MDT-PUDSP22001-R1-PUD.pdf Markup Summary

SHEET 01 OF 25
PUDSP 22 1

SHEET TITLE:  
**SITE PLAN**  
**SP01**  
 SHEET 05 OF 28

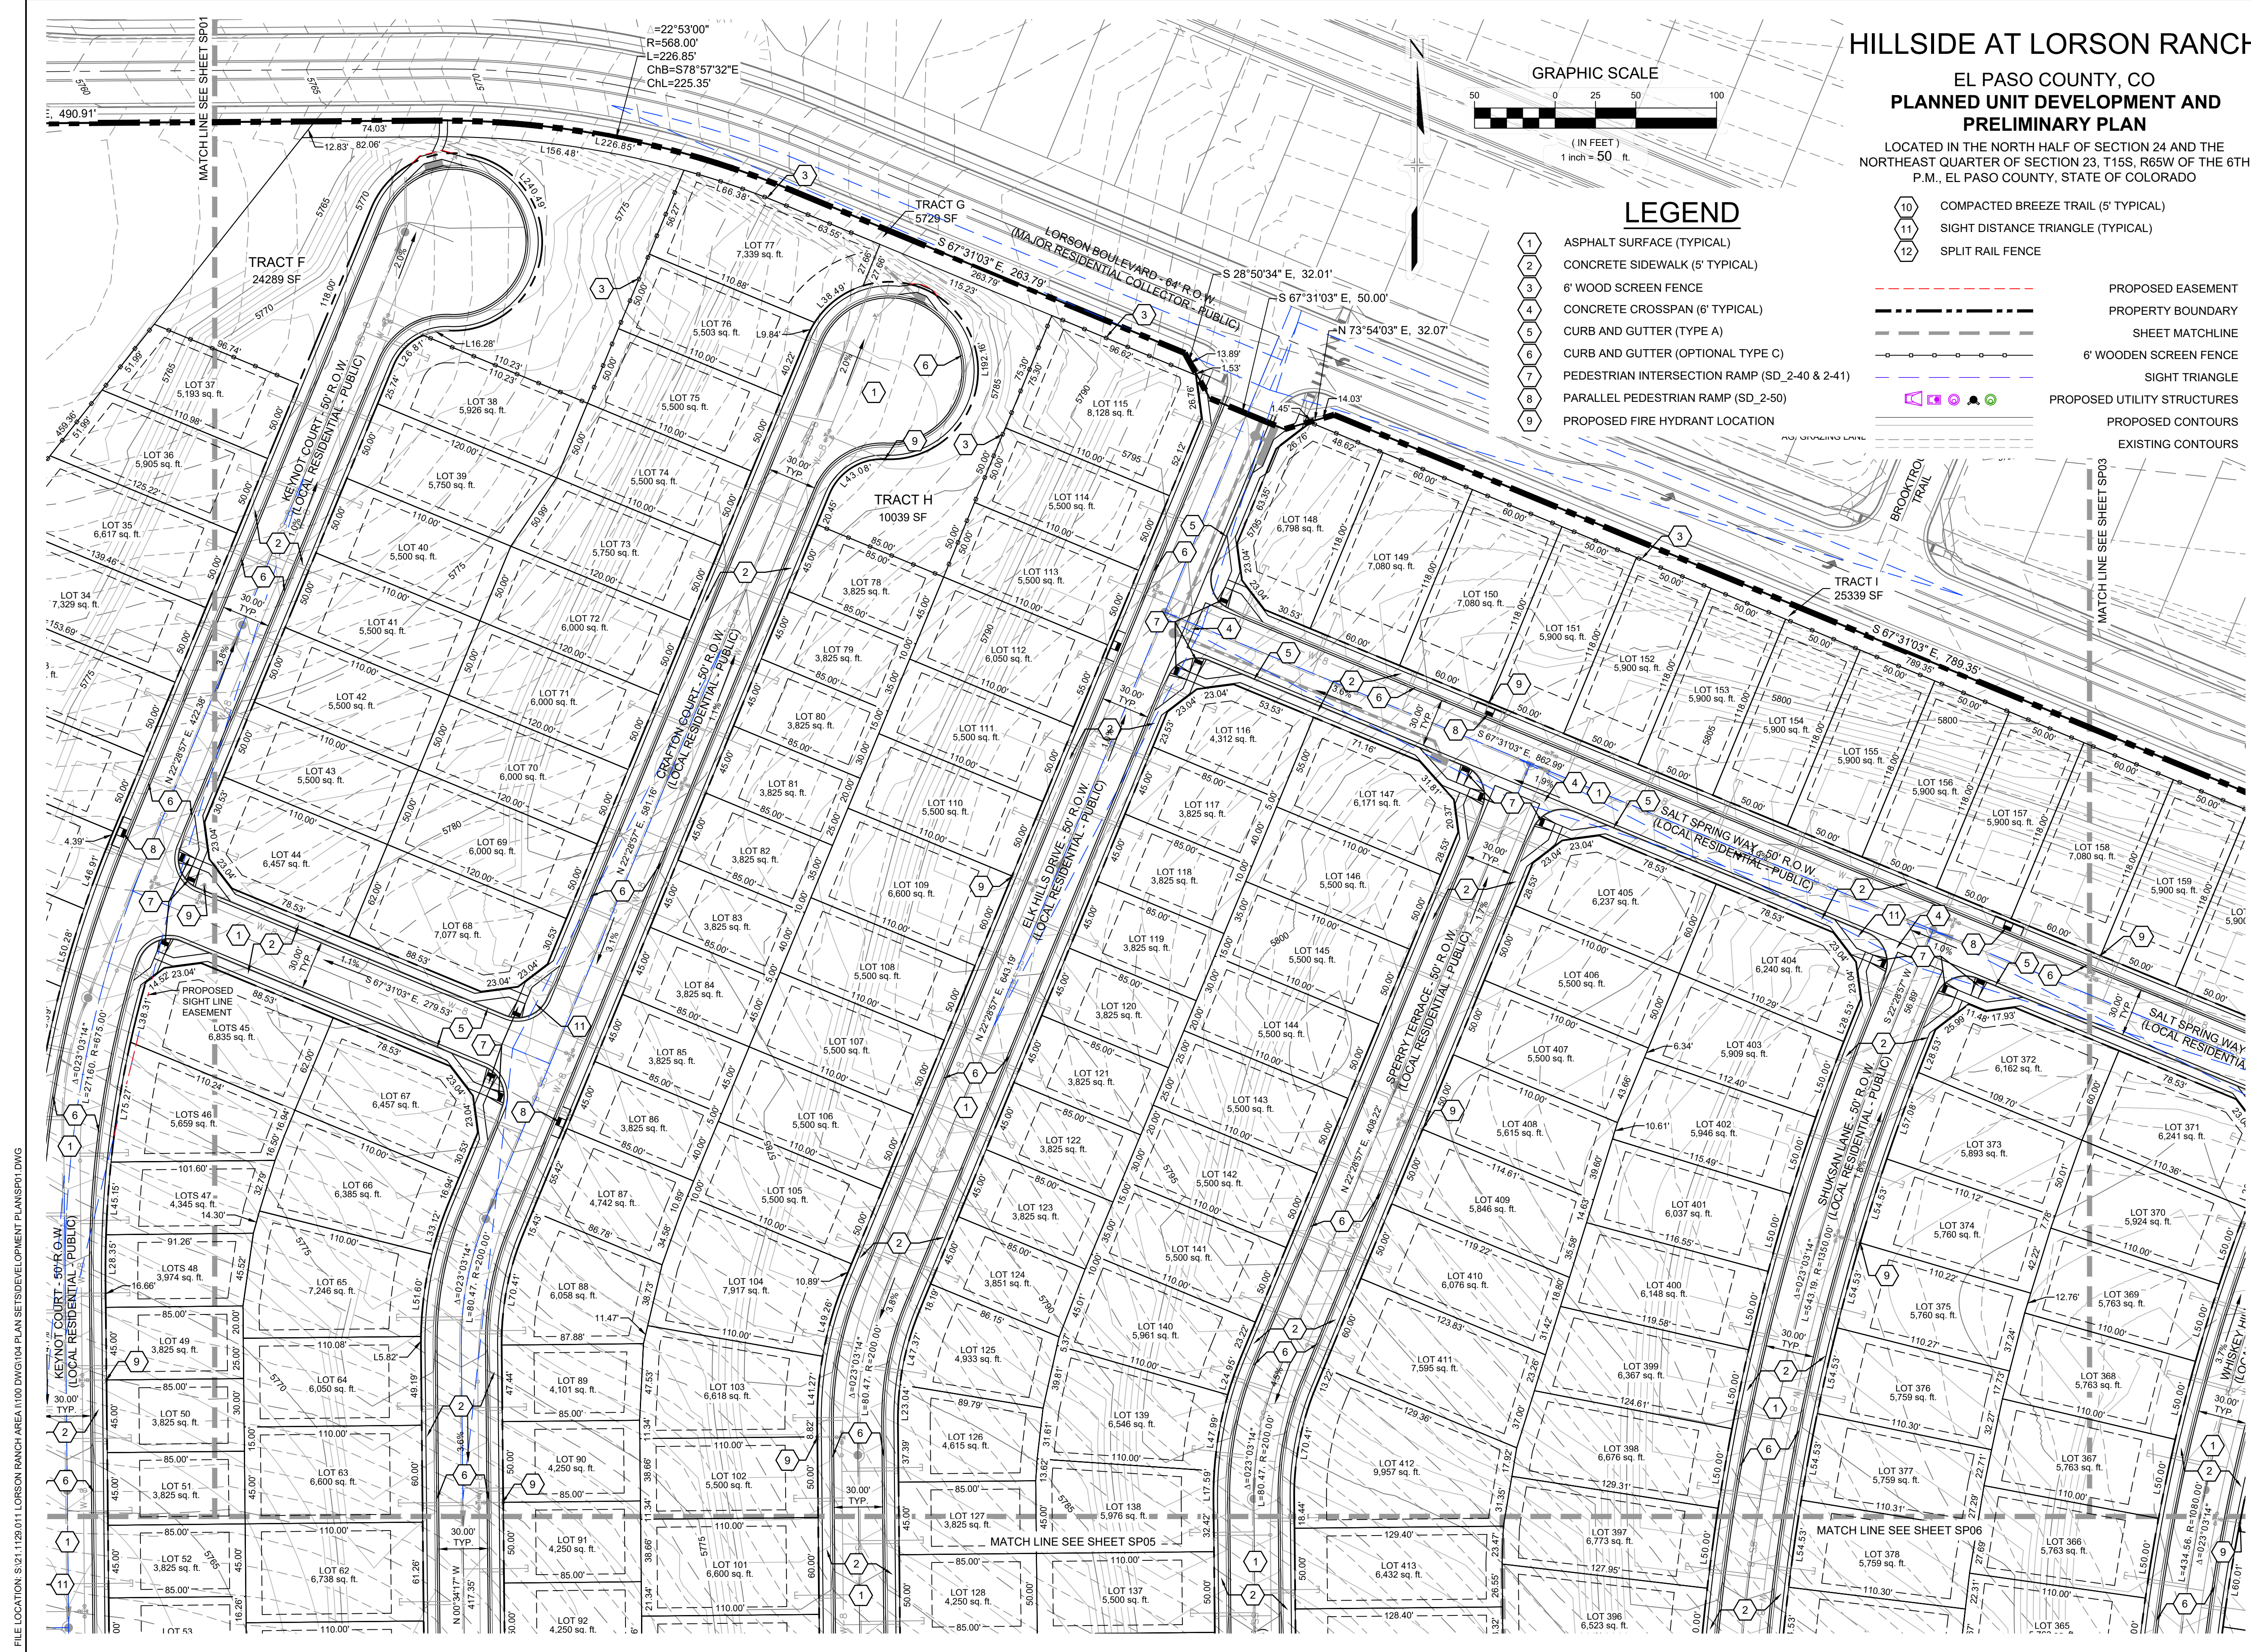
label distance and bearings

STATE is this to be installed by developer, district, or ind builder? State maintenance entity of fence.

are you really using cedar wood panel fencing?
 That may just blow over; is split rail more appropriate?

Show PBMP maintenance roads (all applicable sheets)

boundary of subdivision needs distance bearings

### SP02

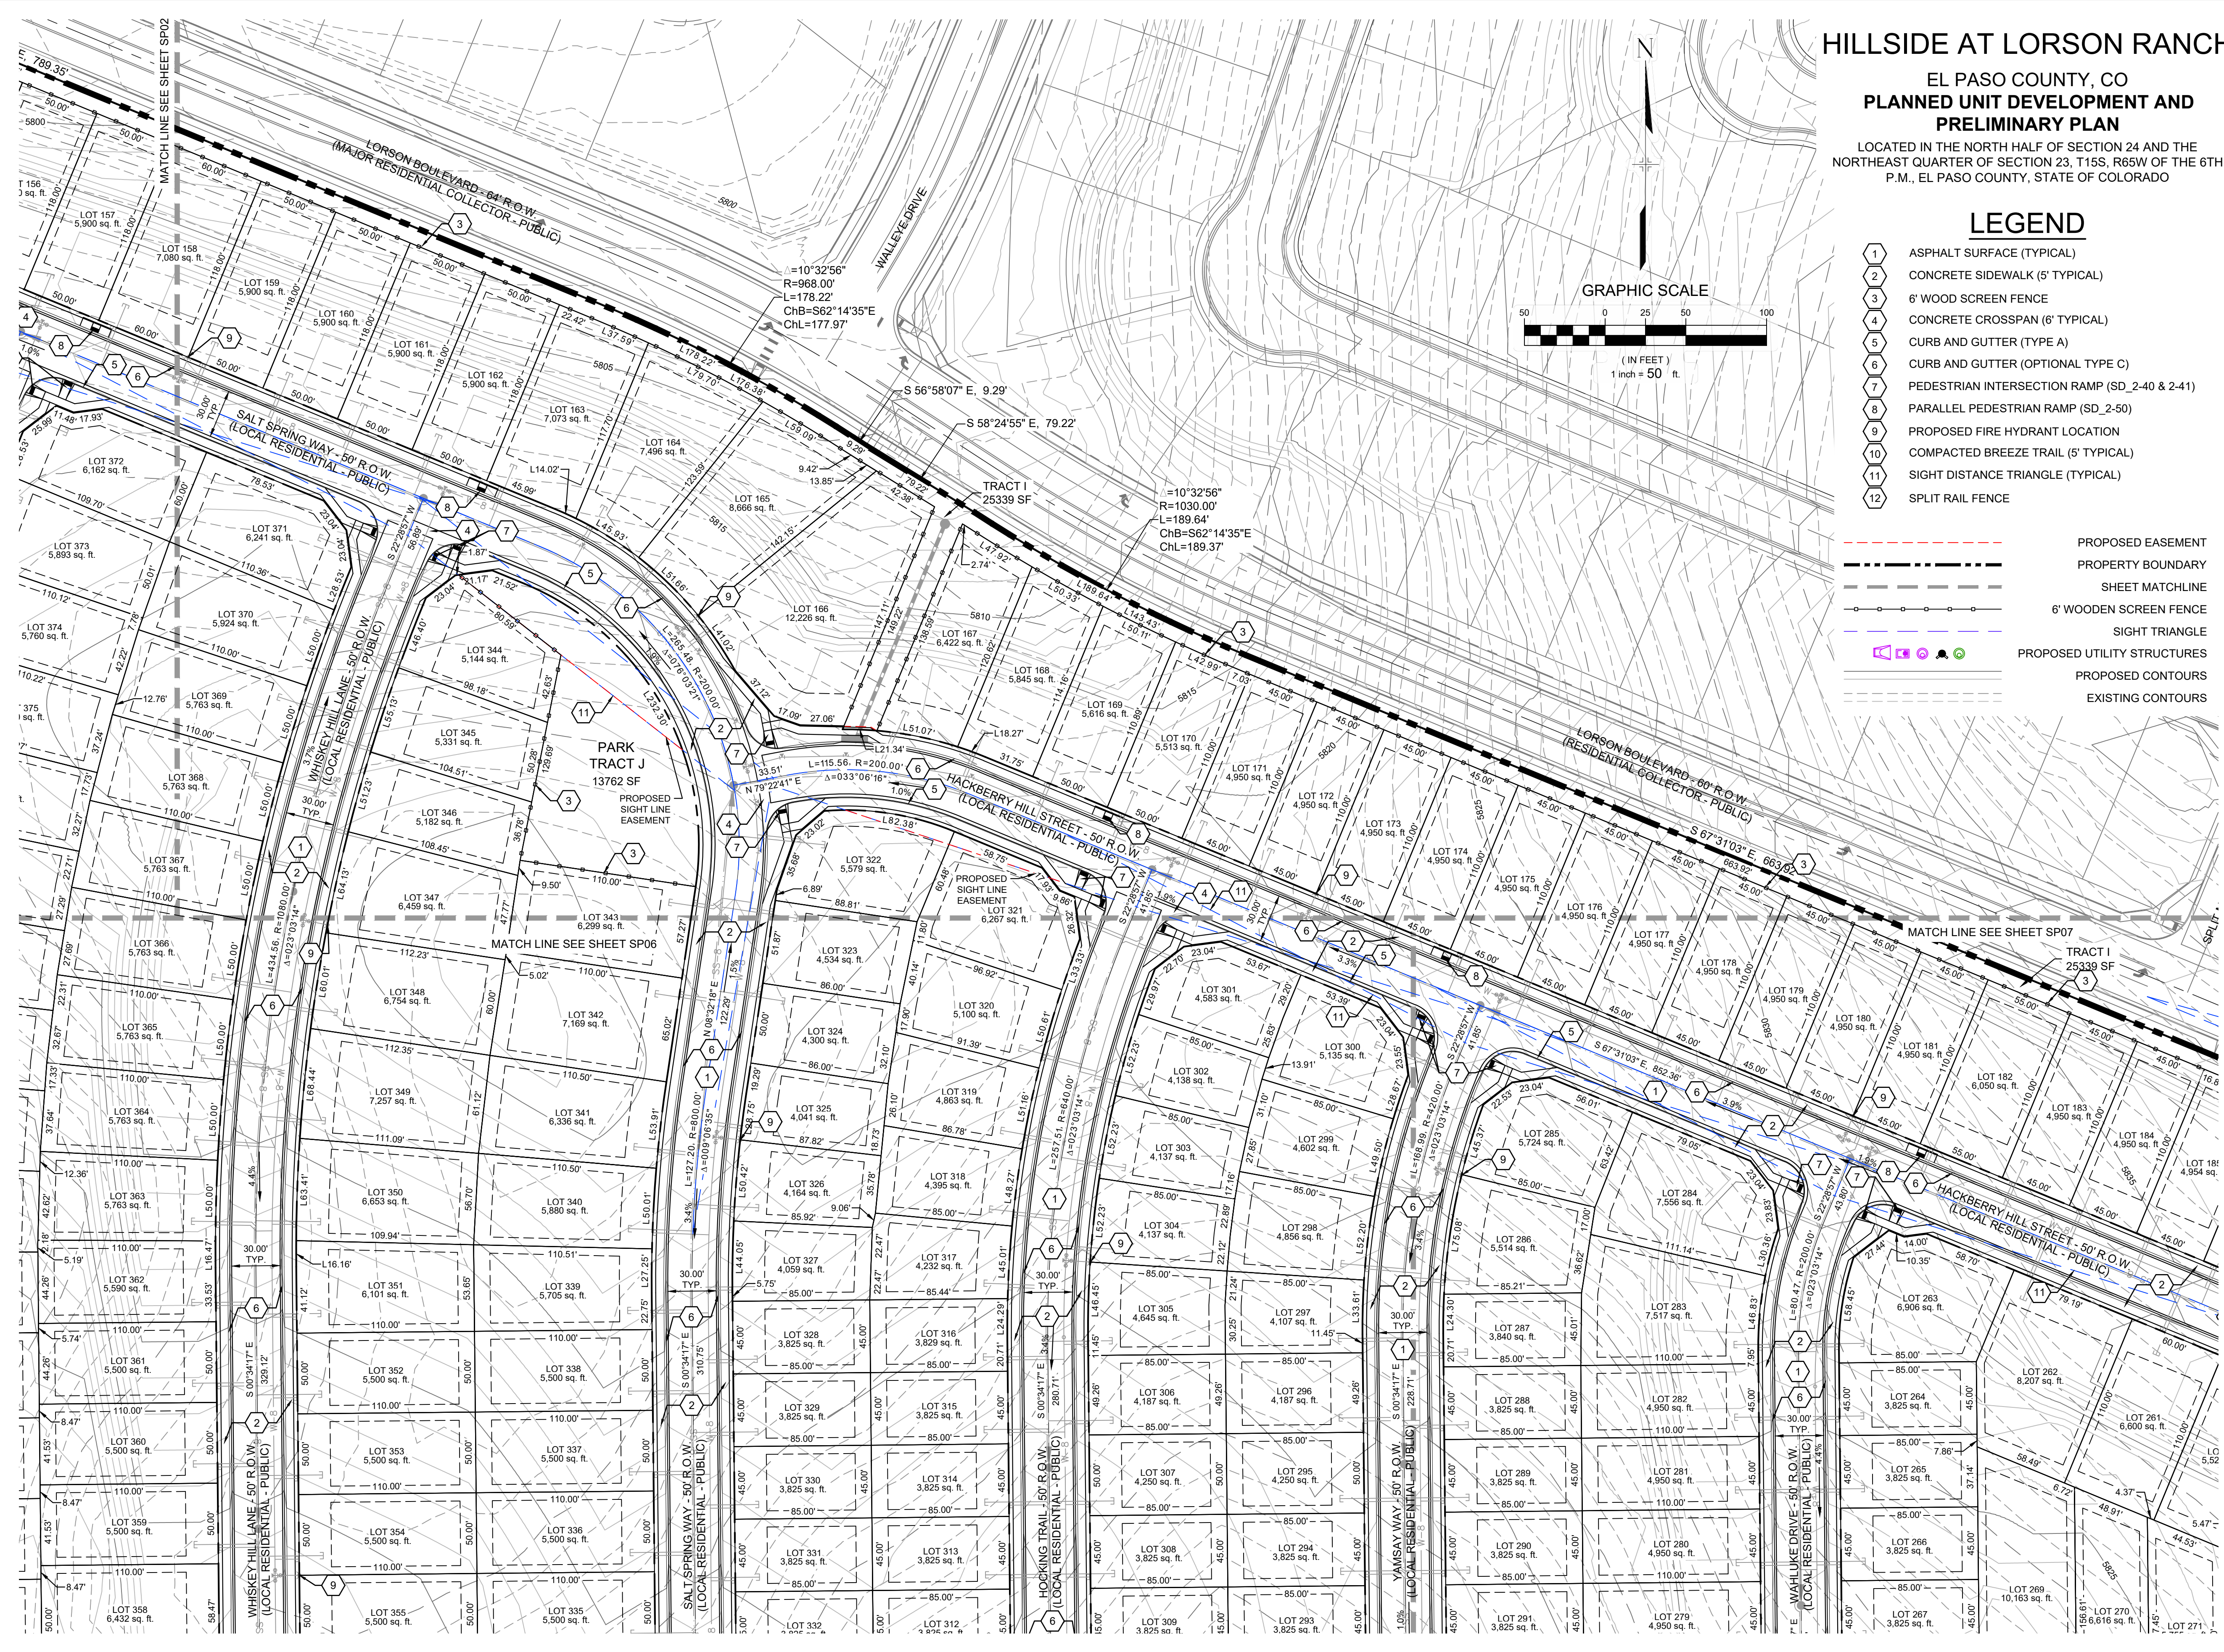
boundary of subdivision needs distance bearings

sidewalk is not in ROW adjust please.

Consider adding a sidewalk connection

## SP03

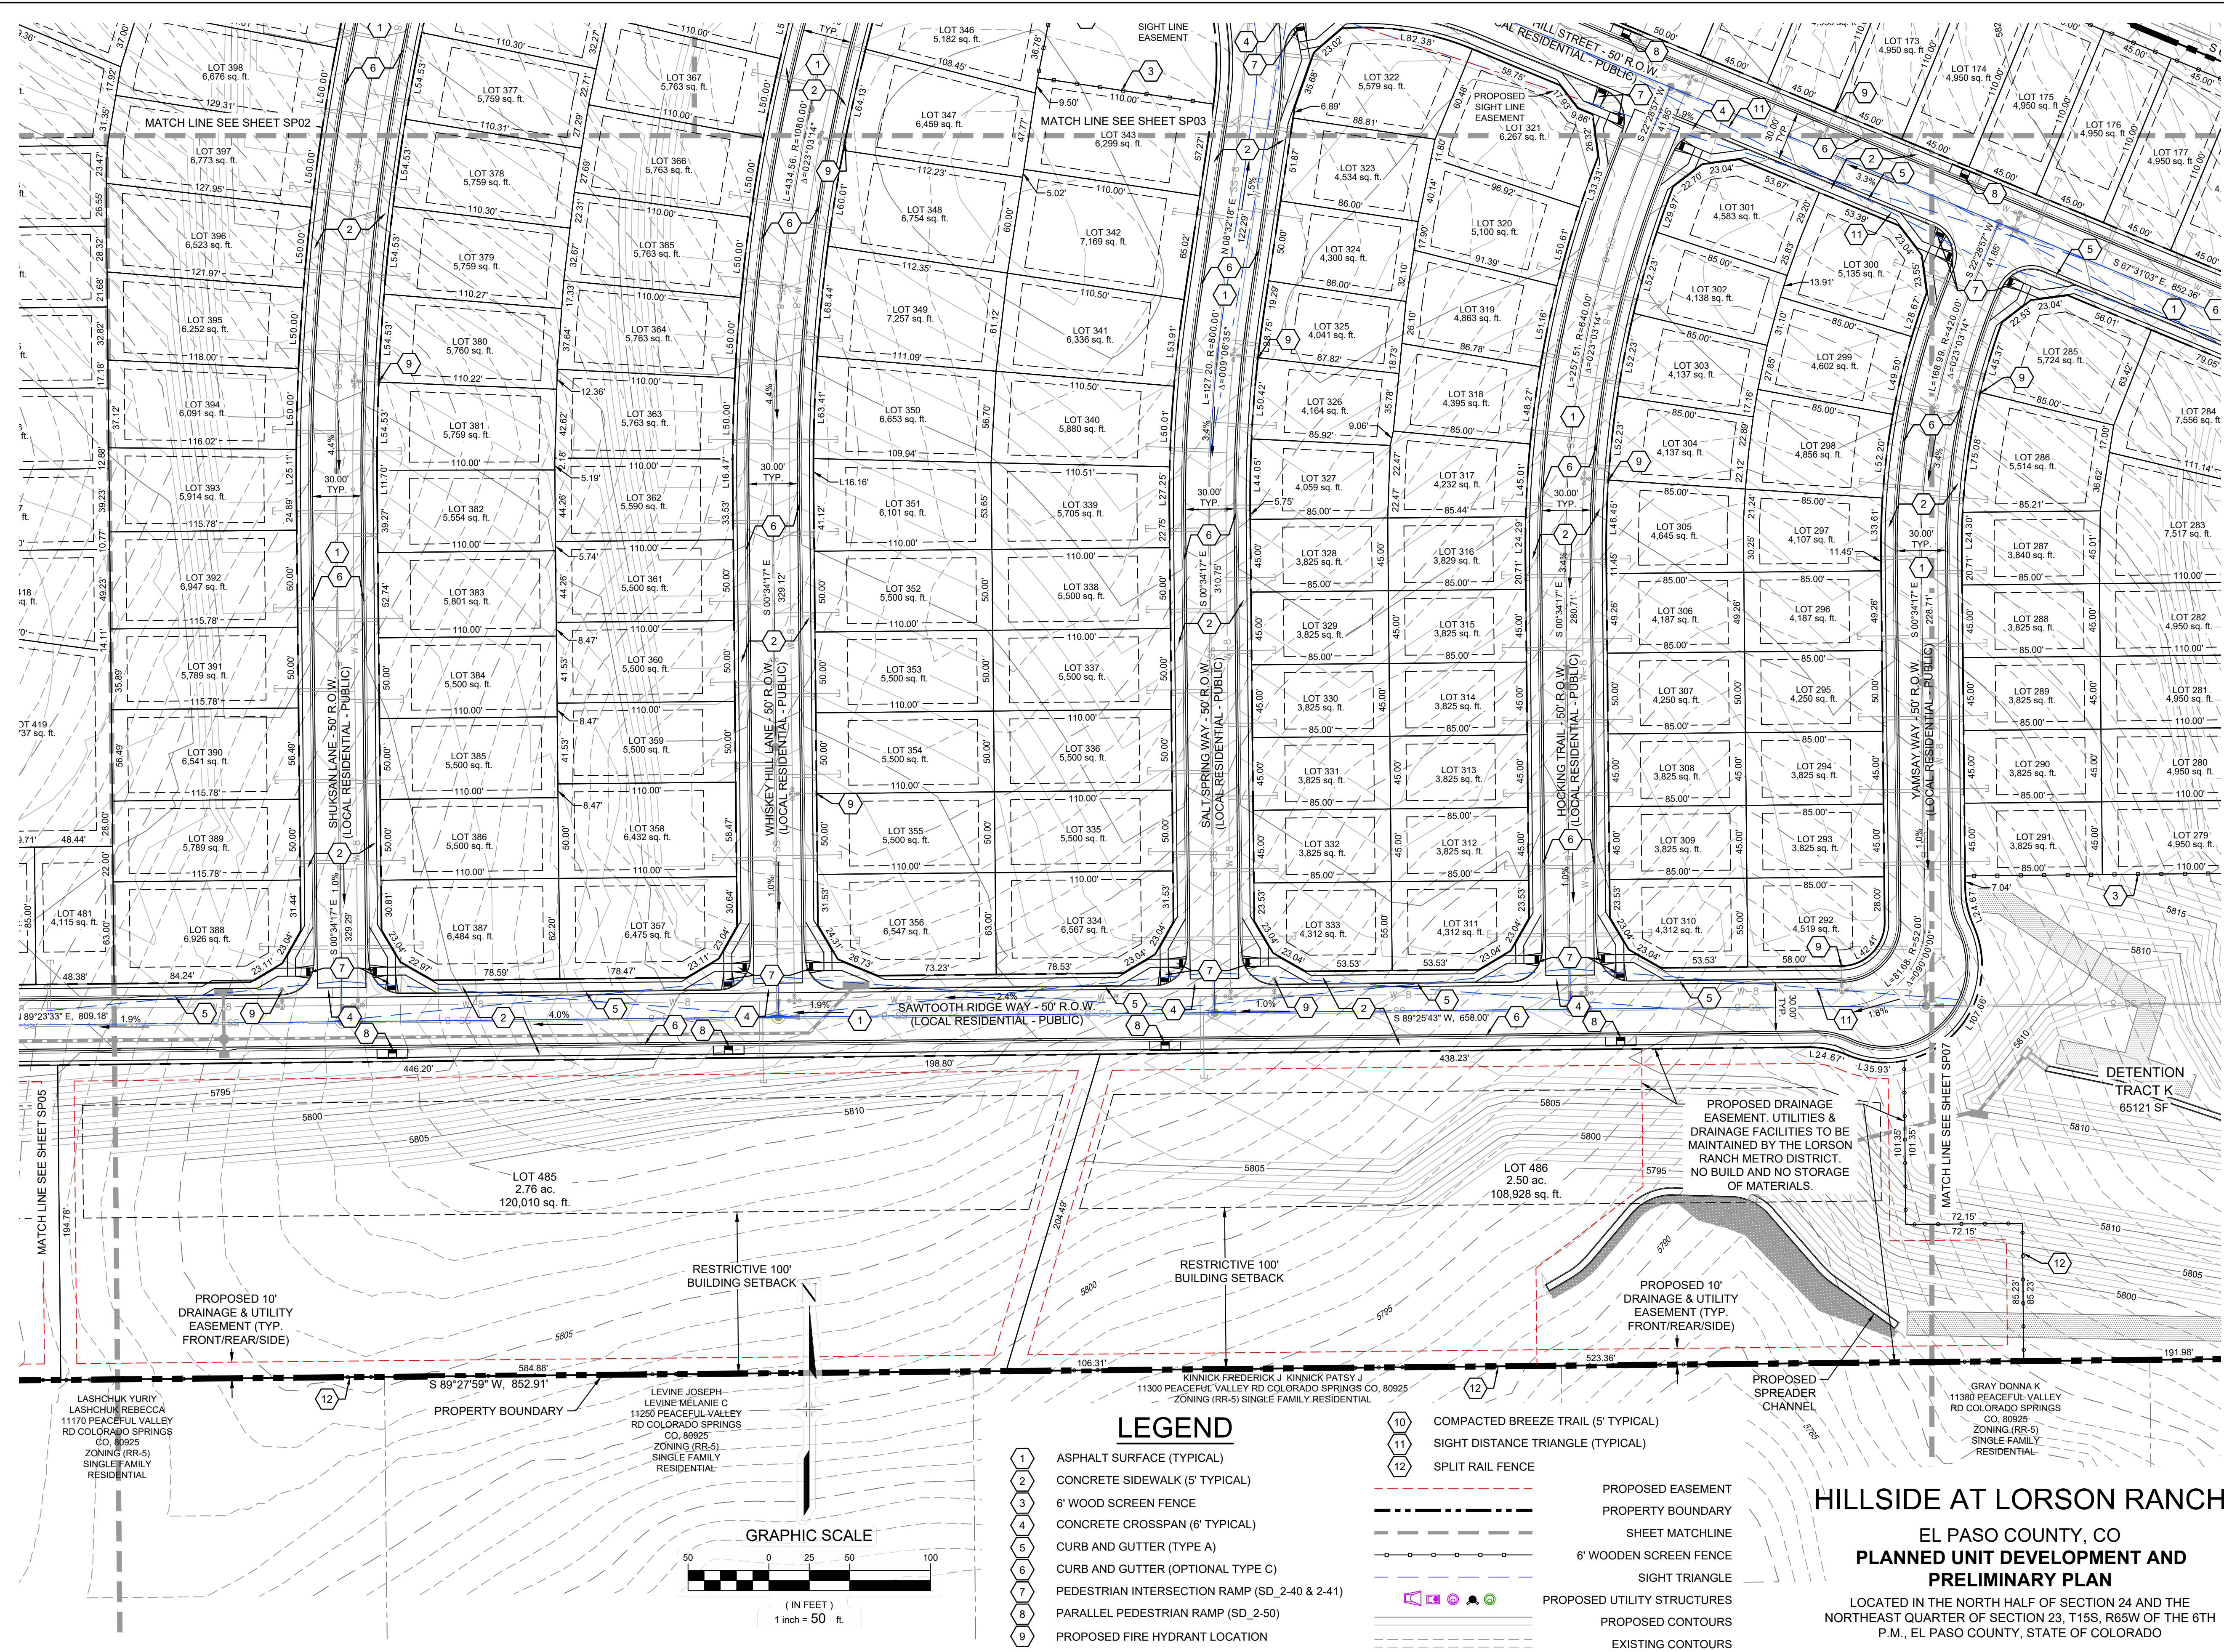
sidewalk does not fin in ROW

Add contour labels on the major contours

Consider adding a sidewalk here or here

Adjust sight distance line to be 280'
